Engineering comments:
-Add current PCD Project File # COM-2243 to the Site Development Plan
-HWY 24 is a 100ft ROW not 60ft. Correct SDP drawing
-Site Plan says Page 1 of 2. Only 1 page submitted. Please correct.
-Applicant to ensure proper CDOT Access permits for HWY 24 are submitted and accepted by CDOT

PREMIER AUTO & RV WAREHOUSE BUILDING
11155 E. HIGHWAY 24
FALCON, CO 80931
EL PASO COUNTY, COLORADO

1 SITE PLAN
 SCALE: 1"=50'-0"

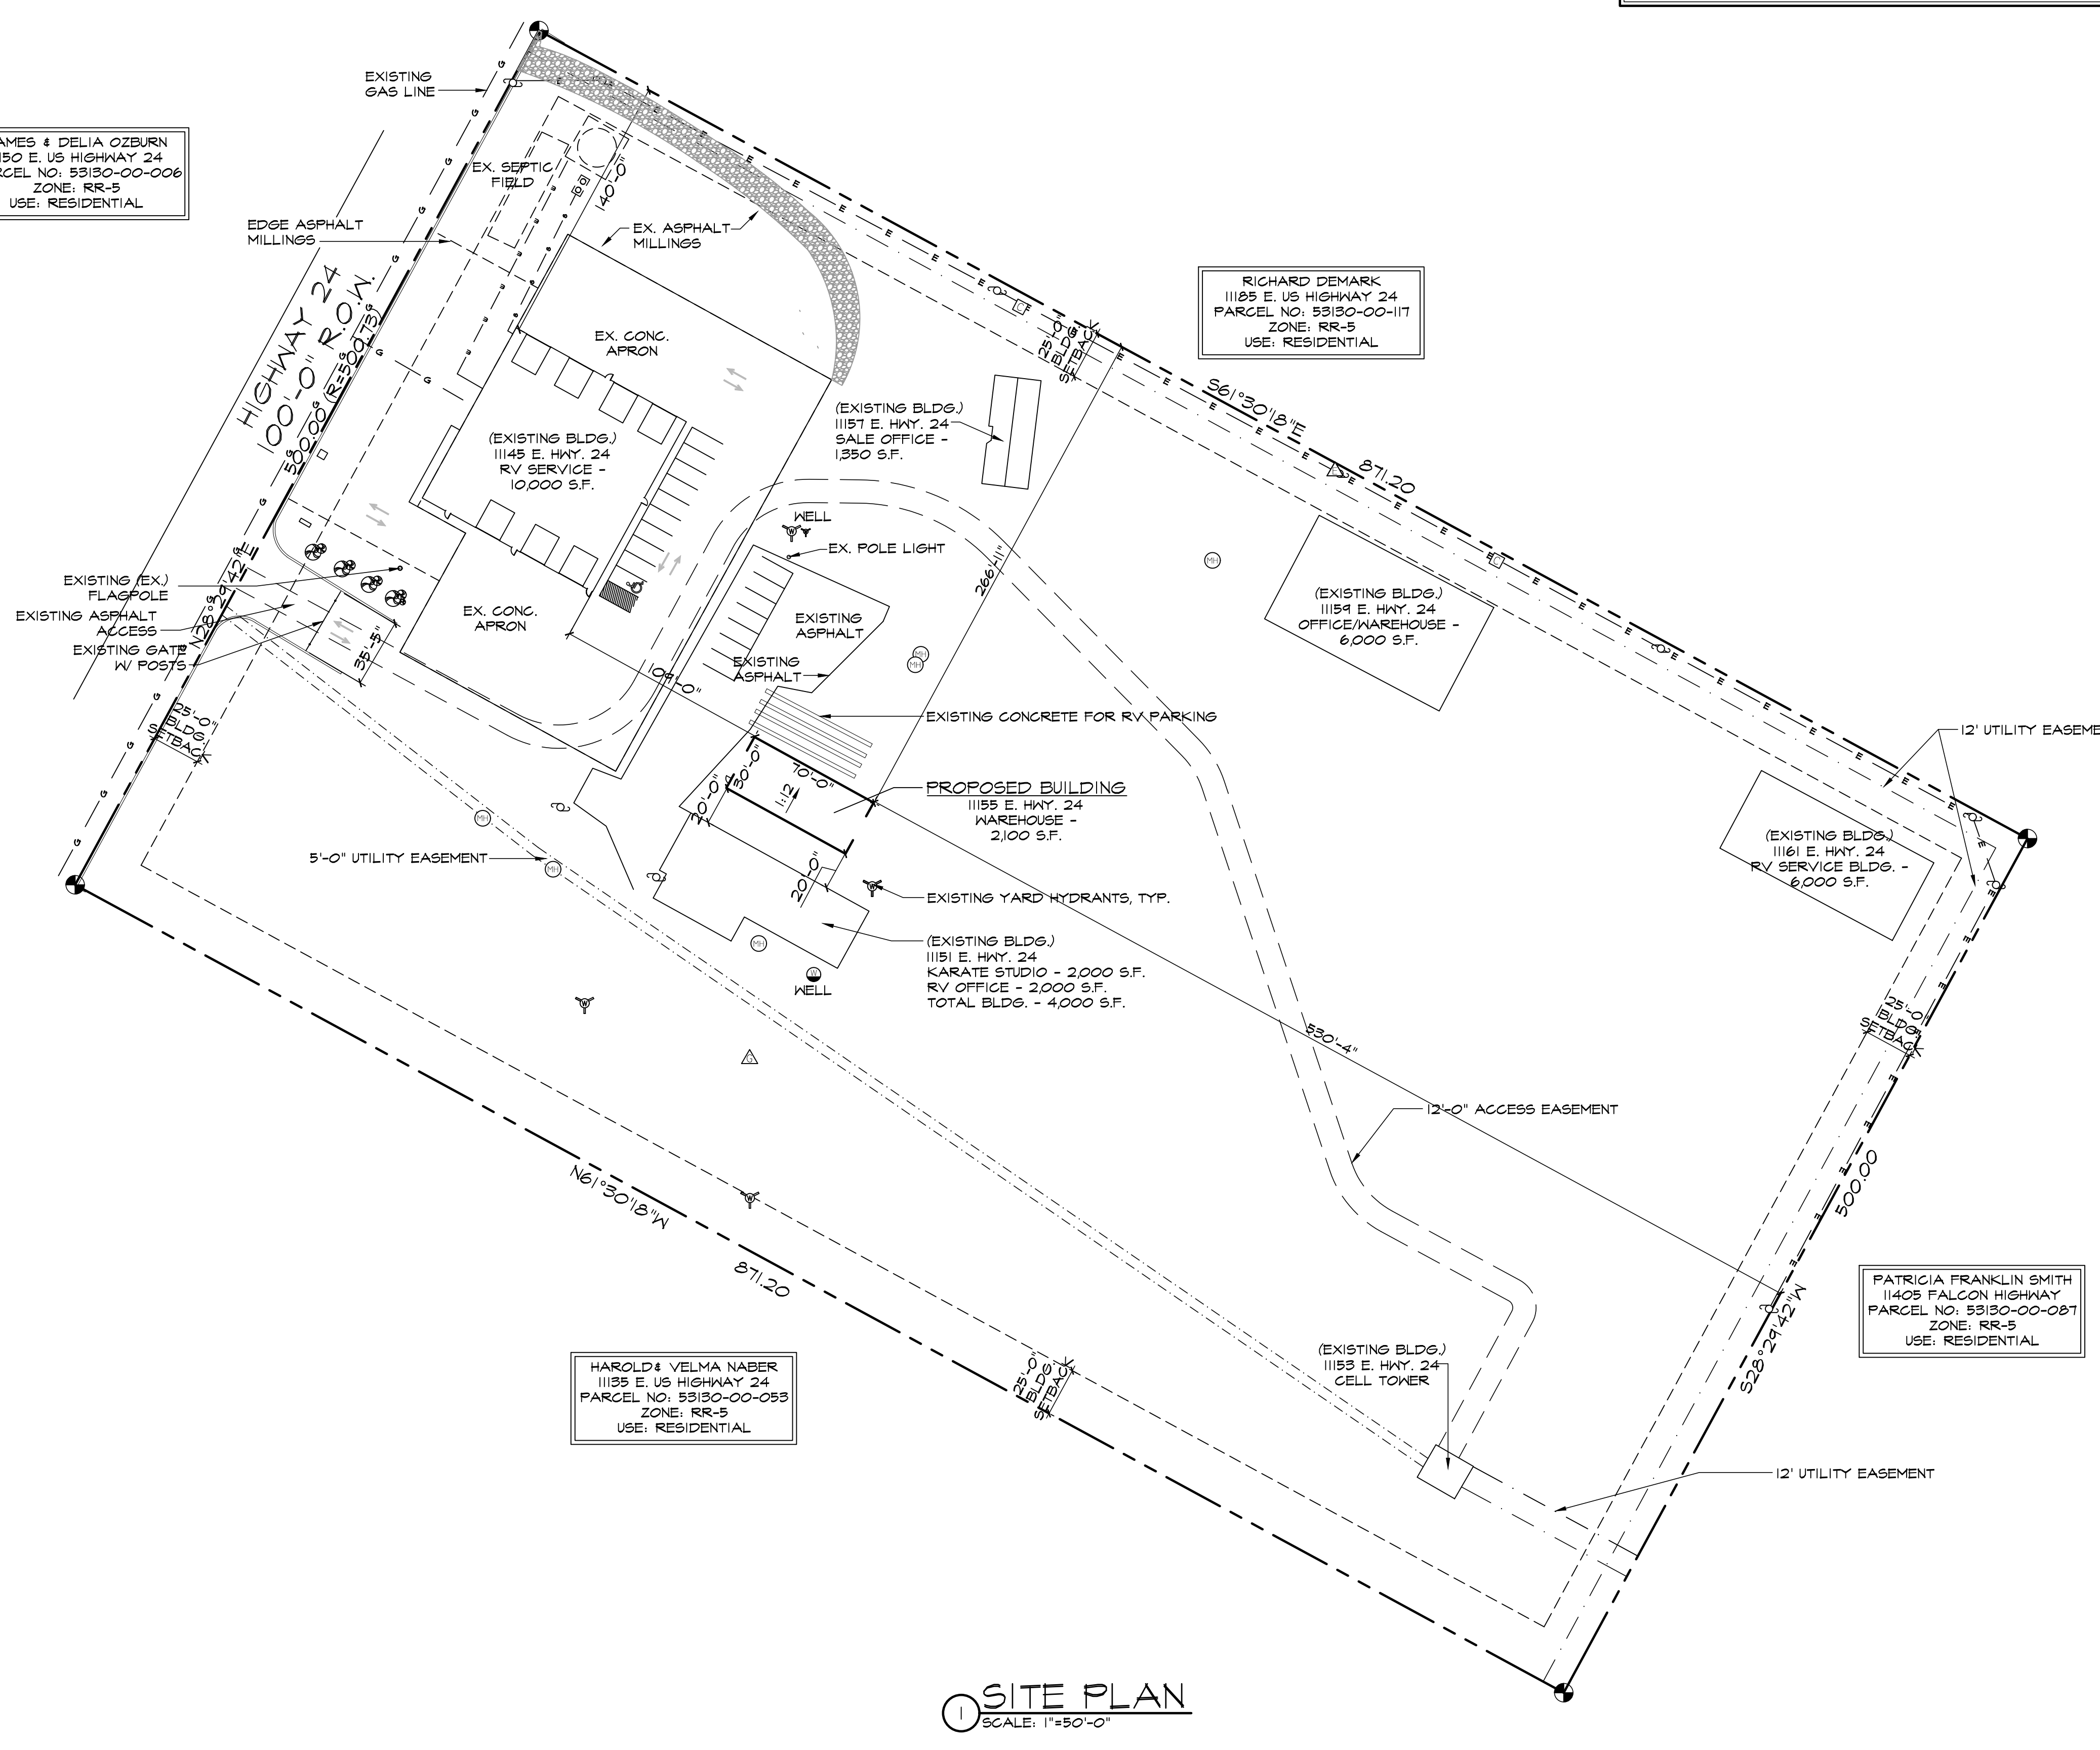
Please include:
- inform CDOT that they are no appreciable changes to the traffic from the site based on the current permit based on the new building.
